Our ref: DOC21/906321

Notice of Exhibition of application for Upper South Creek Advanced Water Recycling Centre (SSI 8609189)

- *Upper South Creek Advanced Water Recycling Centre Project. Statement of Heritage Impact*, prepared by Extent Heritage and dated 5 May 2021, and
- *Upper South Creek Advanced Water Recycling Centre Project. Historical Archaeological Assessment* prepared by Extent Heritage and dated 13 August 2021.

Figure 8. Overview of Brine pipeline underboring the Upper Canal.

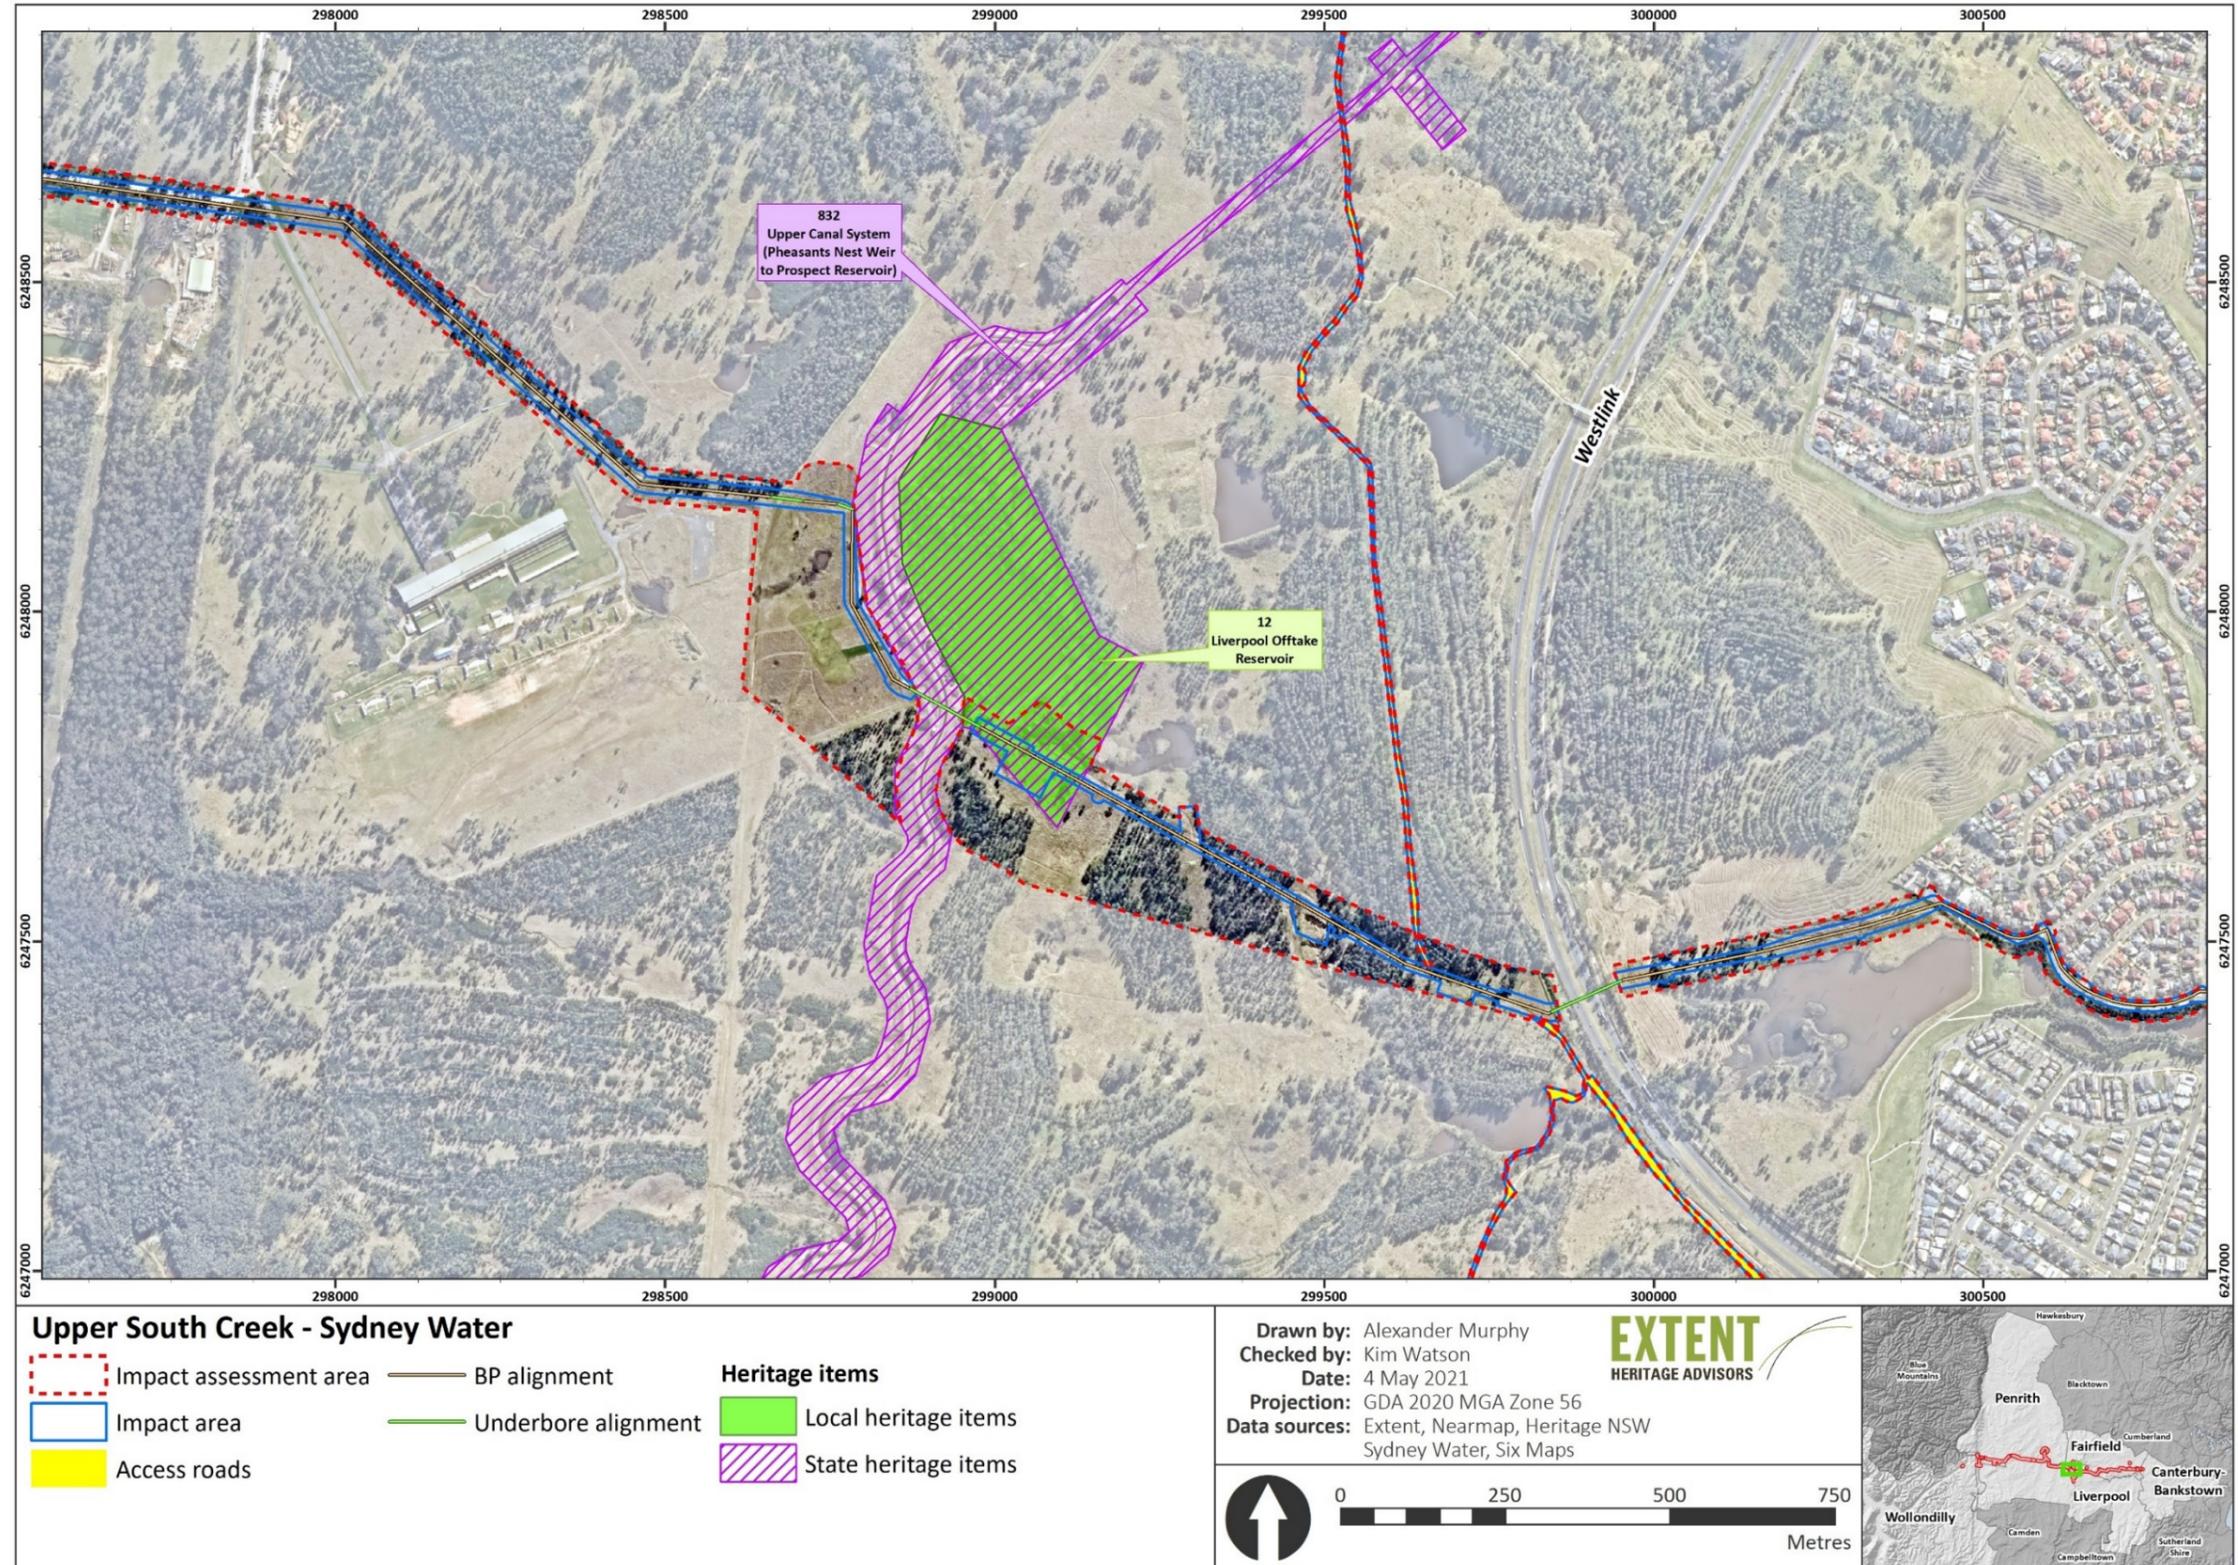
The proposed SSI affects the State Heritage Register (SHR) item Upper Canal System (Pheasants Nest Weir to Prospect Reservoir) (SHR no. 01373) located at Prospect NSW. It is noted that the proposed works intersect with the Upper Canal only at one location. At this location the proposed pipeline is to be installed below the Upper Canal without any direct impact on its heritage fabric. It is however, recommended that the Upper Canal in this area be monitored during installation of pipeline to ensure there is no damage to the Canal due to vibration or impact. If any damage is noticed, work must stop immediately and only resume following rectification and mitigation measures being put in place.

Figure 87. Assessed levels of historical archaeological potential and significance for PAS 8. Source: Near Map, Sydney Water, Extent

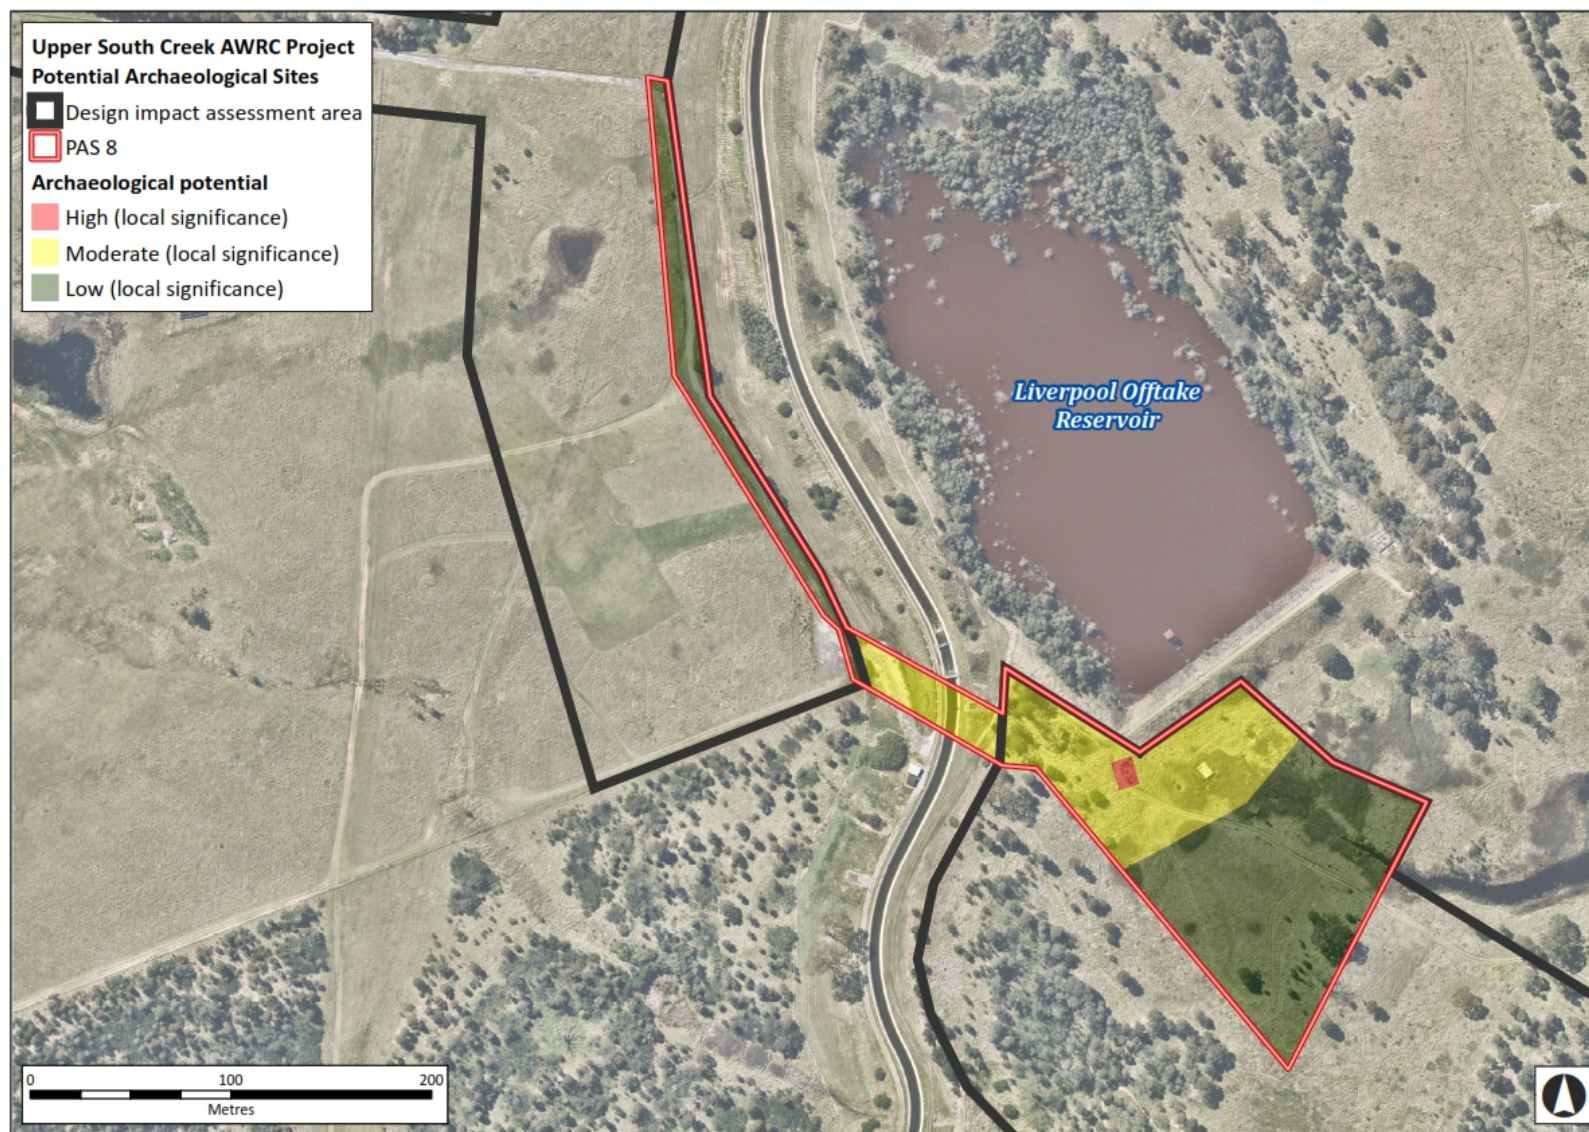
- The mitigation and management measures in this report address the archaeological potential and significance of PAS 1 to 10;
- Heritage NSW supports the recommendation to conduct archaeological testing to establish the presence/absence of State and/or locally significant archaeological deposits in PAS 1, 2, 3, 8, 9 and 10, and assess their nature, extent and preservation status and inform next steps regarding their management.

- Heritage NSW notes that testing should ideally be conducted ahead of decision on the SSI application as preservation *in situ* rather than archaeological salvage is the Heritage Council's preferred approach to managing substantially intact and confirmed State significant archaeology.

- Heritage NSW encourages the Applicant to make further efforts to achieve avoidance through redesign in cases where State significant archaeology is identified within the development footprint.

- It would be a preferred outcome to conduct the testing as early as possible prior to finalizing design in the area of the State significant archaeology and to commit to avoidance and protection of these remains as part of the project. HNSW seeks confirmation of this approach by the Proponent for the project at RTS stage.
